WILLOWTREE PLANNING

RE: RESPONSE TO REQUEST FOR ADDITIONAL INFORMATION – SSD-82548708

PROPERTY AT: 24, 26 AND 28 MIDDLE HARBOUR ROAD, LINDFIELD

Reference is made to **SSD-82548708**, which seeks development consent for the purposes of a residential flat building (RFB) with affordable housing and Build to House (BtH) housing at 24, 26 and 28 Middle Harbour Road, Lindfield (the Site).

Client **DELOITTE**
Project **24-28 MIDDLE HARBOUR RD, LINDFIELD**
Title **TREE MANAGEMENT PLAN**
Original Size **A1**
Drawing No: **LD-DA002**

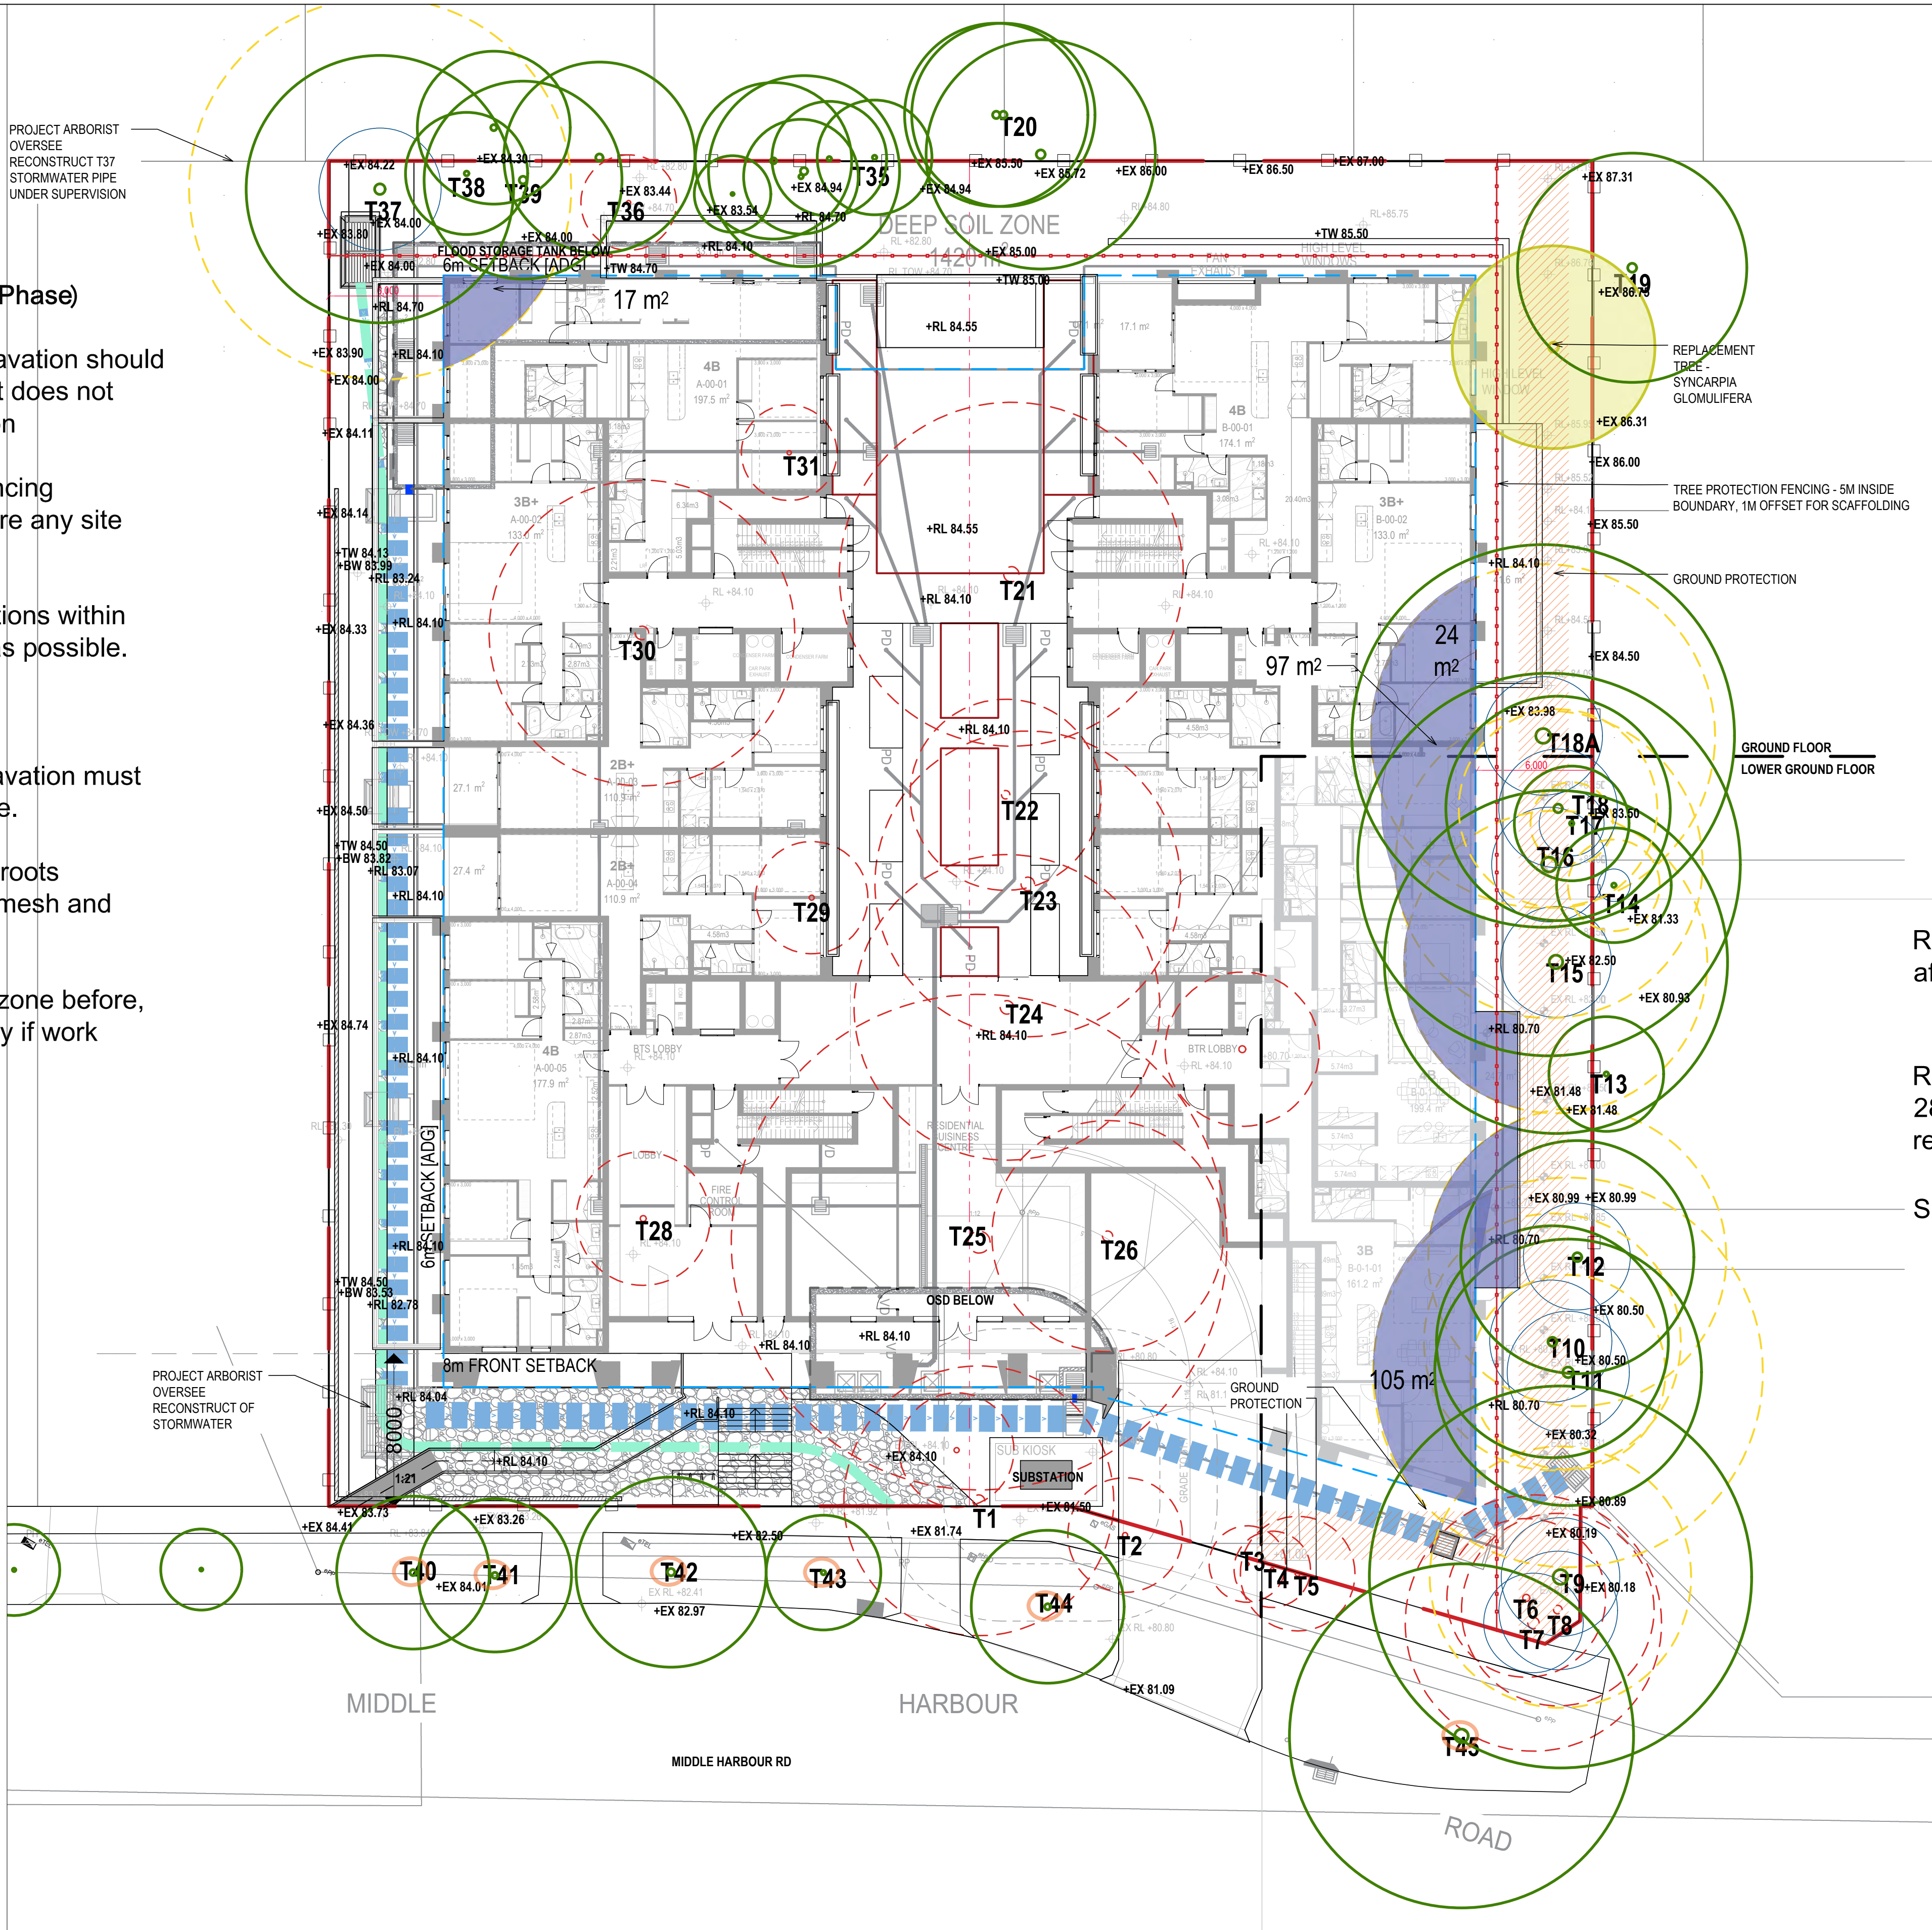
Item	Submission	Response
Biodiversity		
1	Tree 18 - further information request The AIA concludes that Tree 18 cannot be viably retained under the current design. CPHR notes that this tree forms part of a critically endangered ecological community and was originally proposed for retention. In line with the requirement to avoid and minimise impacts	As detailed in the Arboricultural Impact Assessment (AIA) Addendum provided in Appendix 4, the tree has now been nominated for upon further by a Level 5 Arborist and root mapping investigations. Canopy impacts have been amended and clear measures provided to ensure its protection. All reasonable adjustments to the design that can be made to retain the tree and limit disturbances have been made. Any further modifications would require the

Item	Submission	Response
2	Tree 37 - further information request The AIA outlines several options to minimise impacts to the TPZ from proposed stormwater infrastructure (rerouting, horizontal drilling, hand excavation). A definitive approach must be selected. Recommended action: ▪ Update the AIA to clearly specify the exact method proposed. ▪ Update all relevant plans to revised alignment if stormwater re-routing is proposed. ▪ If horizontal drilling is proposed: ○ assess and document impacts associated with the entry and exit drilling pits ○ demonstrate that drilling within the TPZ will occur at a depth >600mm below existing ground level, consistent with AS 4970:2025 ○ update stormwater plans to show: ▪ entry and exit pit locations (drawn to scale) ▪ a longitudinal profile confirming drilling depth within TPZ ○ update the TPS and TPP accordingly.	The Civil Engineering Plans prepared by Xavier Knight require stormwater in the locations shown that are designed to meet the required function, a realignment cannot be made to these elements. It is proposed in the location of Tree 37 to use a vacuum suction truck to carefully excavate this area and therefore minimize impacts to the tree. These works will be undertaken under the supervision of a suitable qualified AQF Level 5 Arborist as a condition of consent.

Item	Submission	Response
	under Clause 6.2 of the Biodiversity Conservation Act 2016 and Section 7 of the Biodiversity Assessment Method 2020 (BAM, 2020), the viable retention of this tree should be prioritised. At present, no clear justification has been provided to demonstrate why the design cannot be amended to facilitate its retention. Recommended actions: ▪ Review and amend the proposal, in consultation with a suitably experienced AQF Level 5 Arborist, to explore whether viable retention of Tree 18 can be achieved. ▪ Address both root-zone and canopy impacts, ensuring the design avoids unacceptable encroachment into the Tree Protection Zone (TPZ). ▪ Provide an updated AIA demonstrating that Tree 18 can be retained viably, including: ○ updated Tree Protection Specifications (TPS) ○ updated Tree Protection Plan (TPP). ▪ If the tree cannot be viably retained, clear justification is to be provided why retention is not feasible and why the design cannot reasonably be amended to facilitate its retention.	significant loss of units in the order of 16 dwellings, however as demonstrated in Appendix 4, this tree may be retained subject to those protection measures and these may be confirmed as conditions of consent.
